Front Range-Midway
Solar Project

Site Layout

Markup Summary

Site Layout

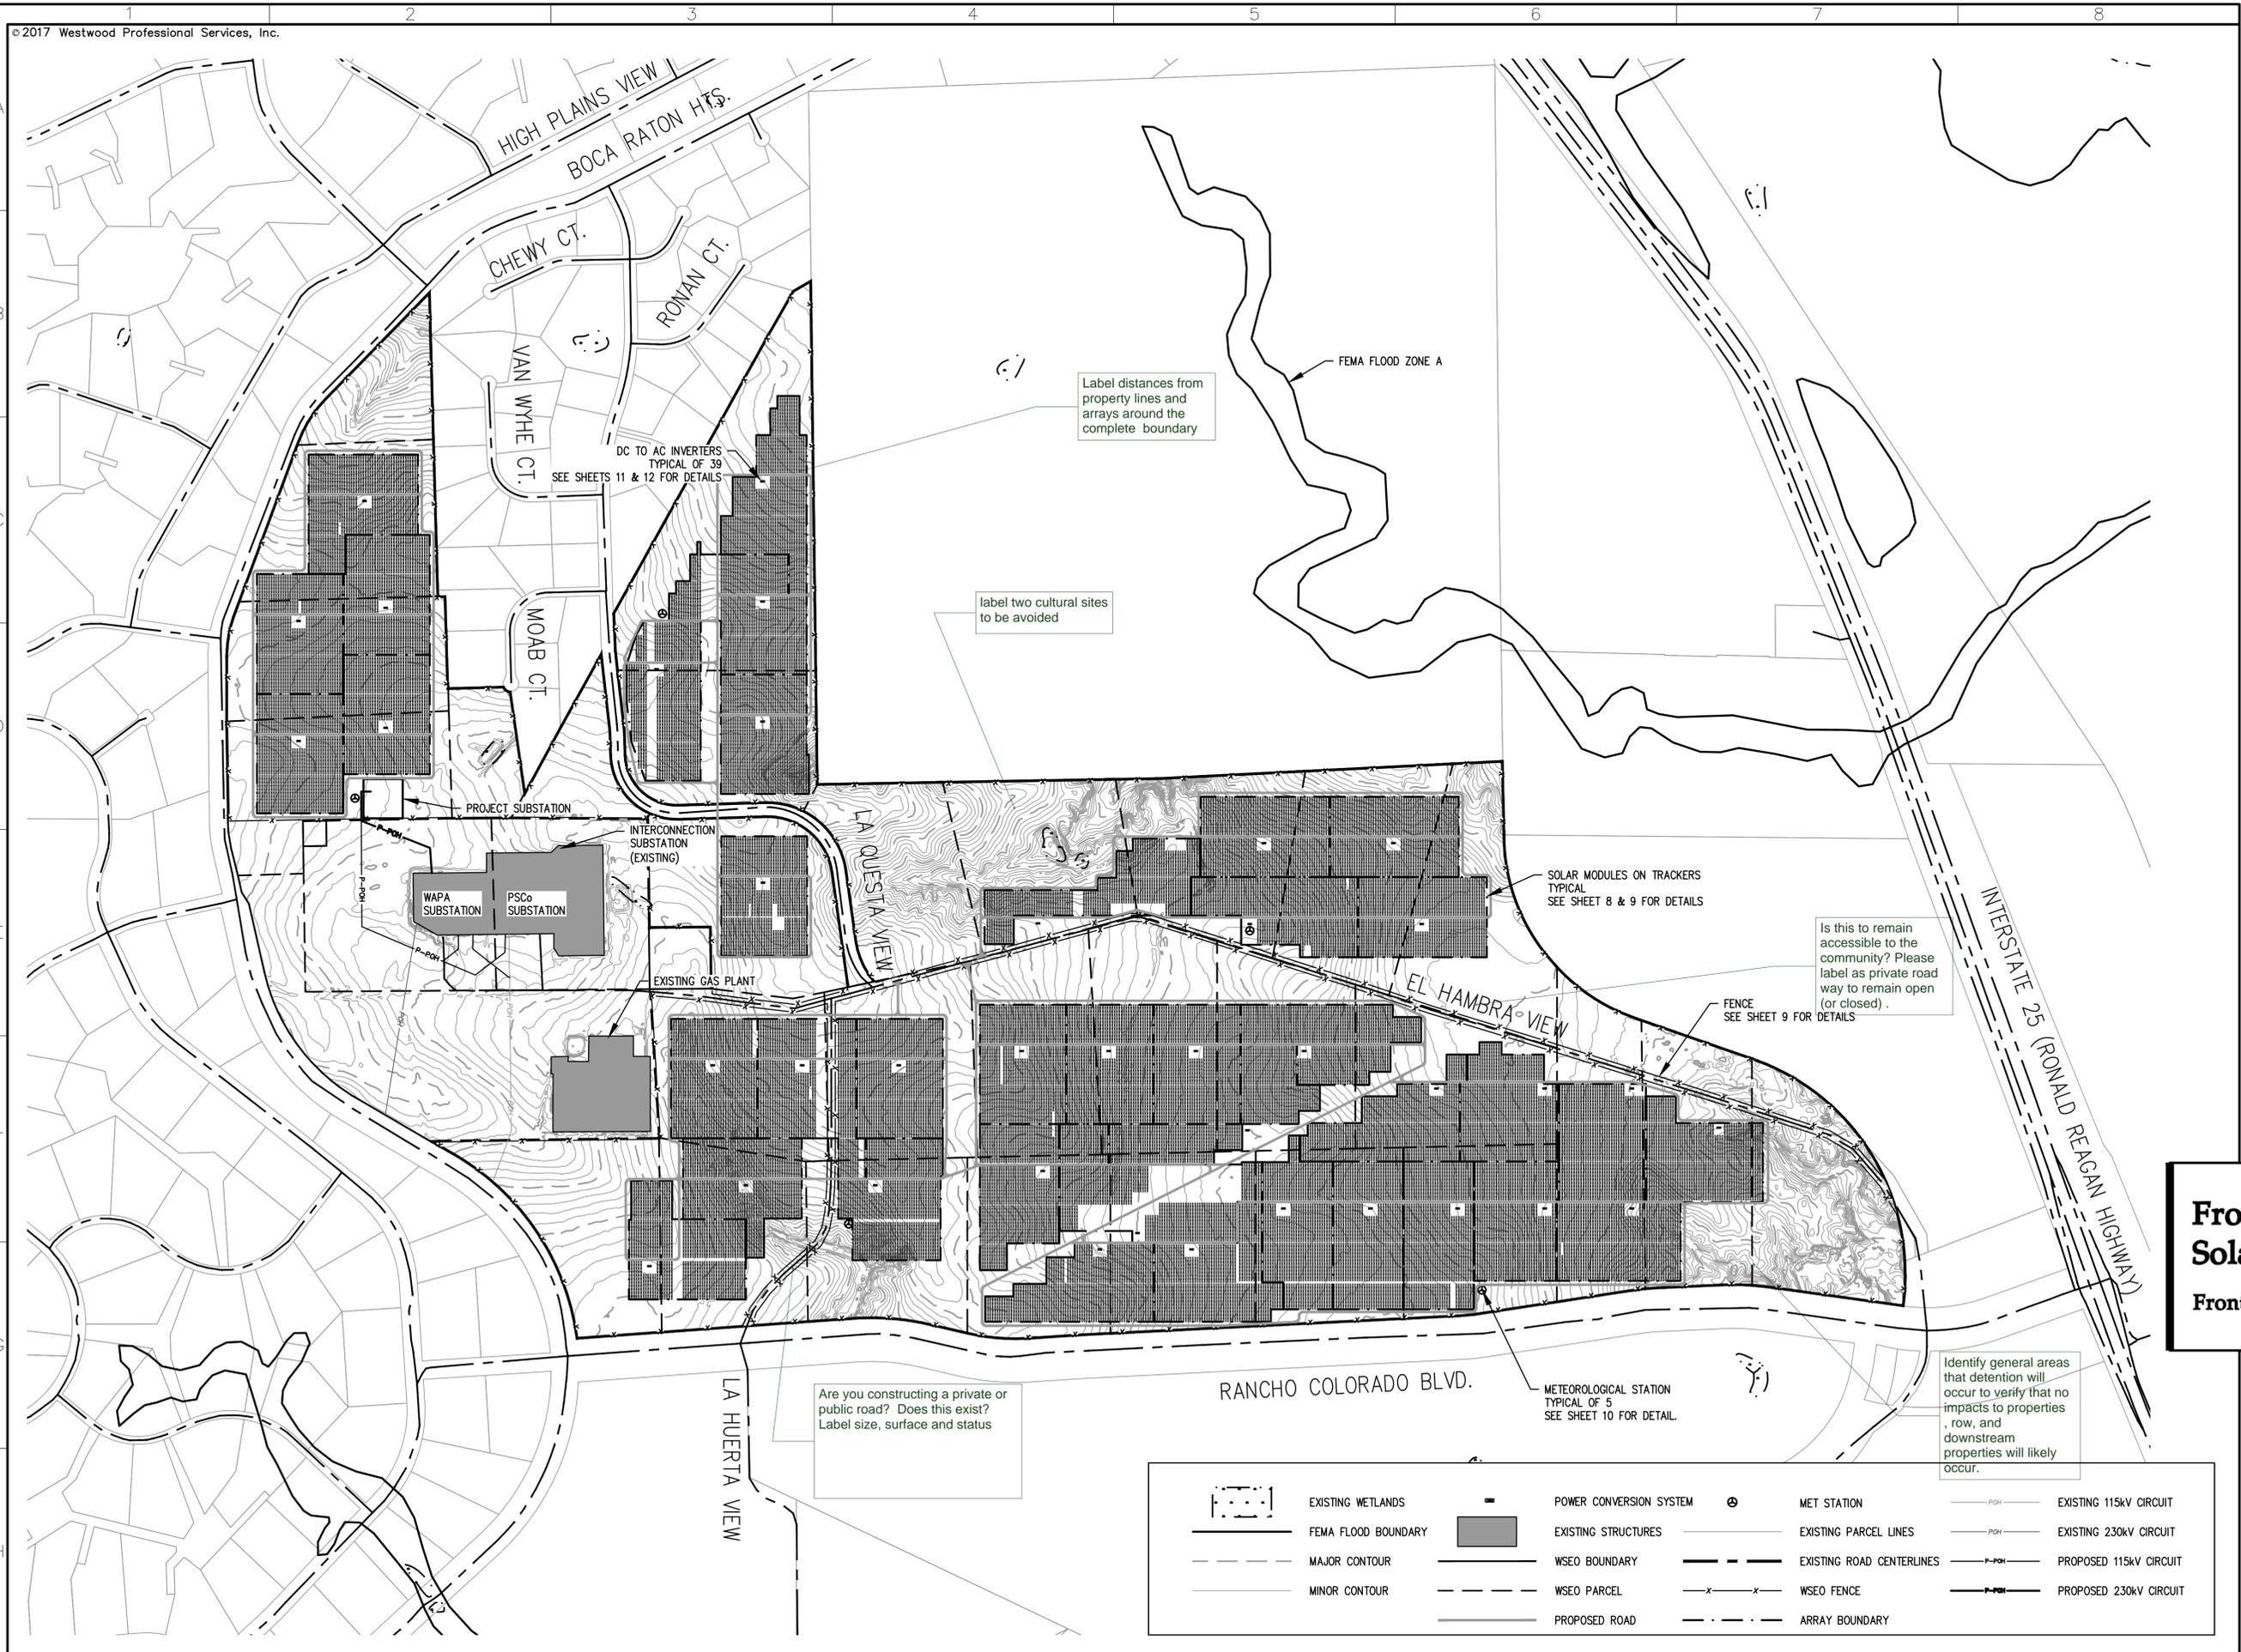
Subject: Callout
Page Label: 1
Lock: Unlocked
Status:
Checkmark: Unchecked
Author: dsdparsons
Date: 11/22/2017 8:00:45 AM
Color: label two cultural sites to be avoided

Subject: Callout
Page Label: 1
Lock: Unlocked
Status:
Checkmark: Unchecked
Author: dsdparsons
Date: 11/22/2017 7:58:07 AM
Color: Label distances from property lines and arrays
